STAPLETON ROW CROSS SECTIONS

WATERBURY SANITARY FORCE MAIN

UTILITY CONSTRUCTION SET
OVERVIEW SHEET

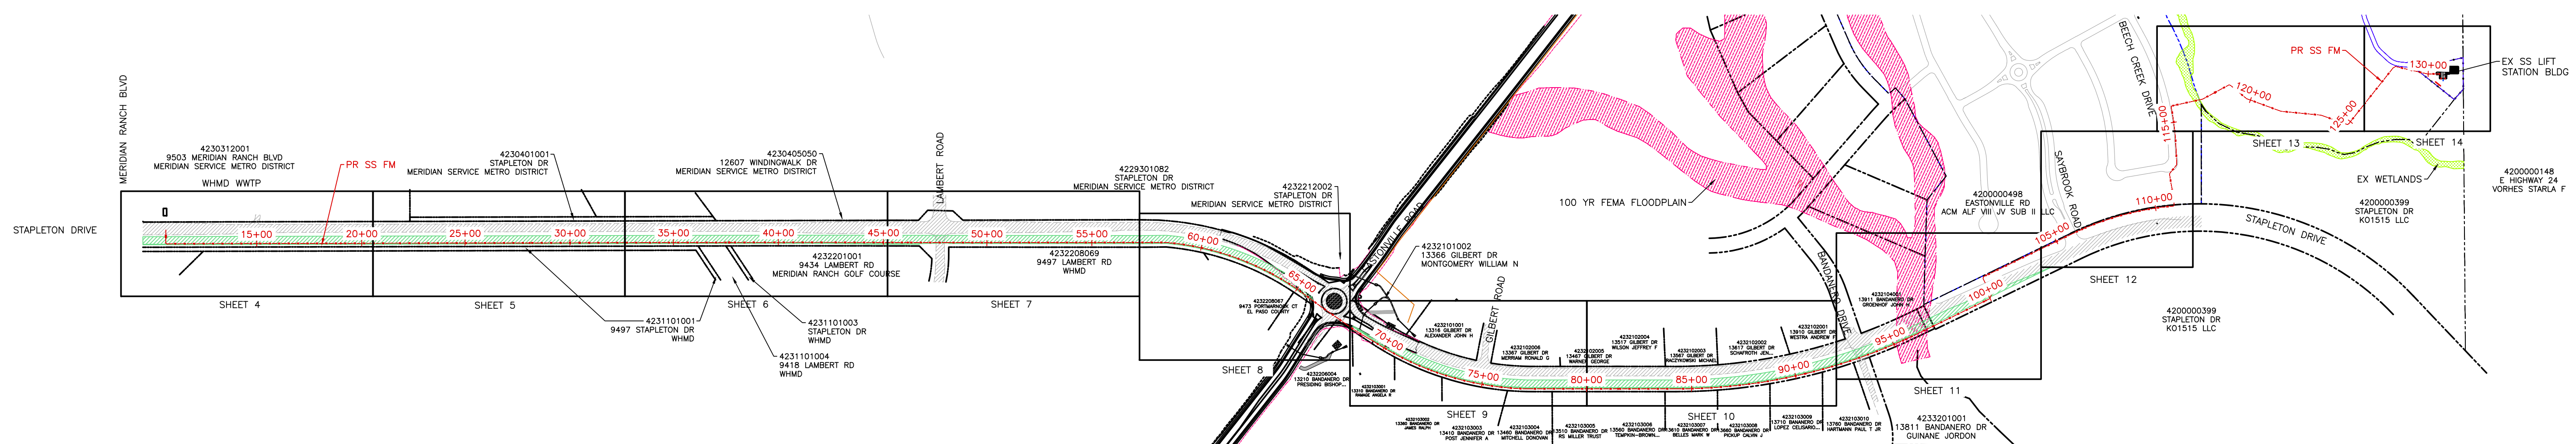
dimension distance to future C&G on each section

ensure that centerline is at correct location - show the actual cross-section if different

These aren't typical sections, they are sections of a specific point. The existing street conditions change a lot and the force main has to avoid multiple obstacles, so there isn't a typical section for this line.
